Your Ref: MP 09_0187 MOD 3

MODIFICATION REQUEST – SECTION 75W MODIFICATION TO MIXED USE DEVELOPMENT AT 6-16 ATCHISON ST, ST LEONARDS (MO-09_0187 MOD 3)

I refer to your letter dated 2 June 2014 concerning the above matter. The proposed modifications have been reviewed by Council Planners and are not supported the reasons set out below.

NOM.ARCH.
DAVID MAYES 3190 JOHN RYAN 3181 BRIAN MANN 5975 ANDREW SCARVELIS

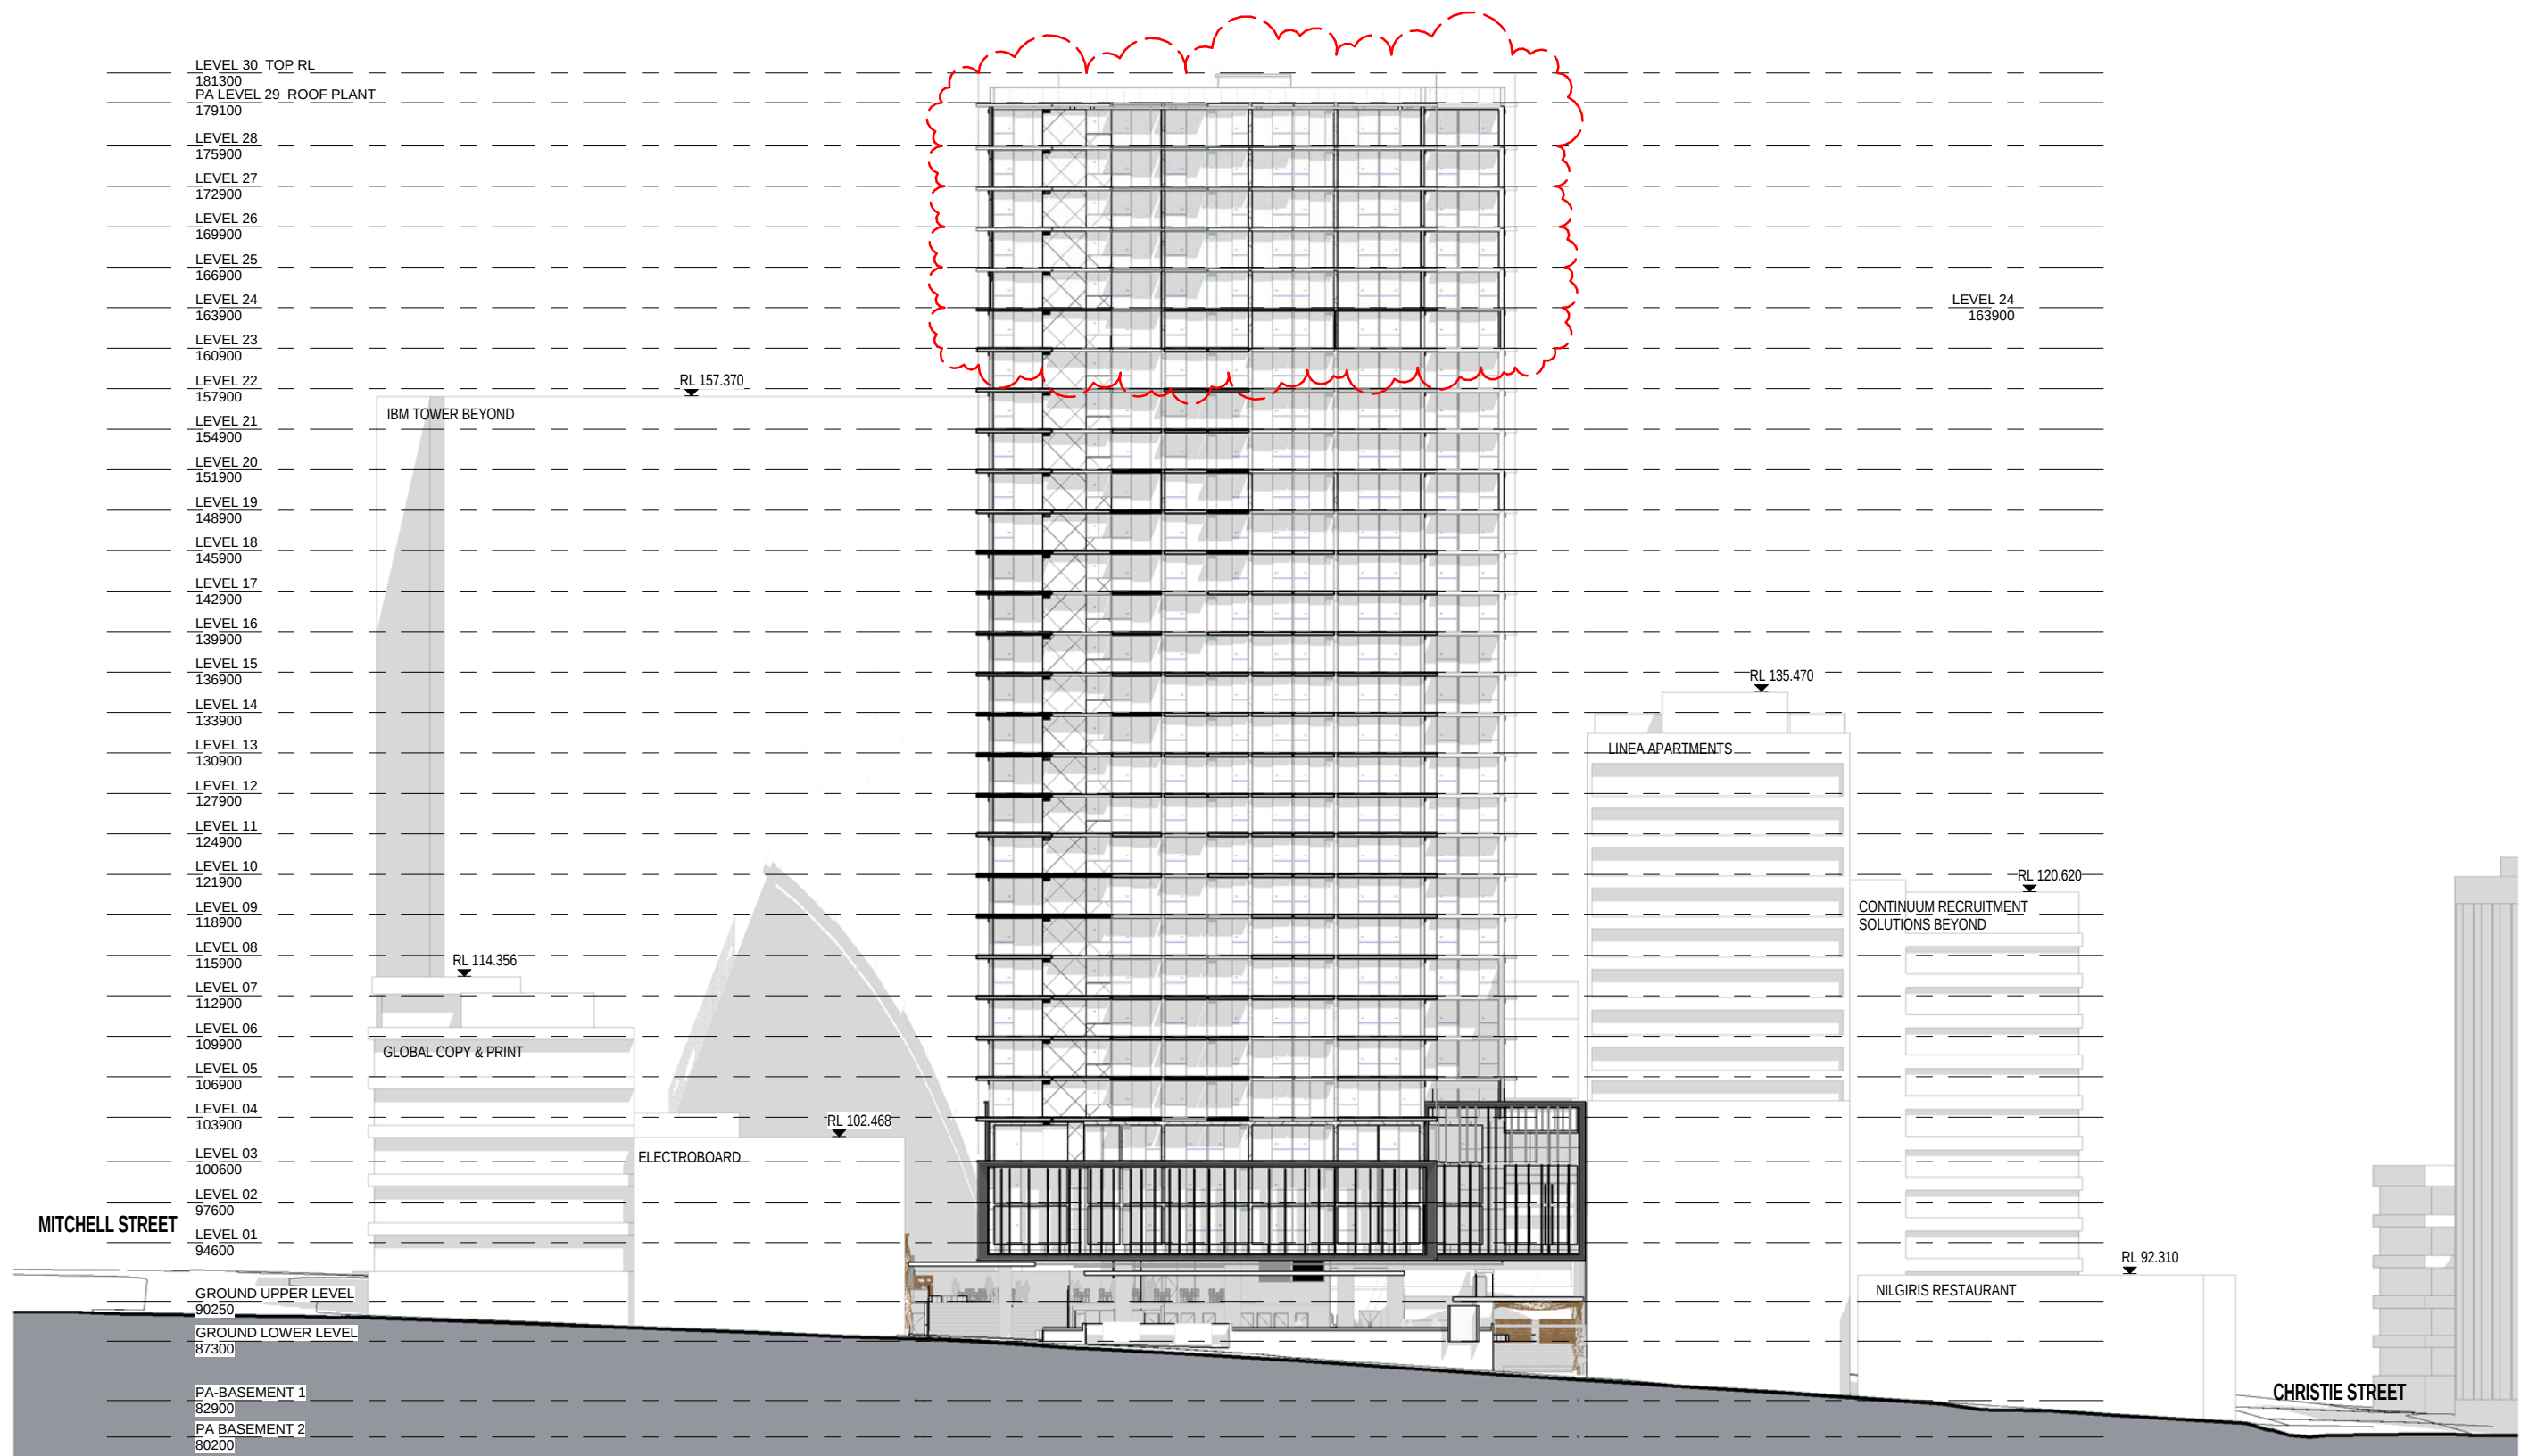
In addition, the modification proposes to provide an additional 34 car parking spaces within the approved 6 basement levels. Concern is raised that the basement has been already approved to accommodate this quantum of additional car parking that has not yet been approved.
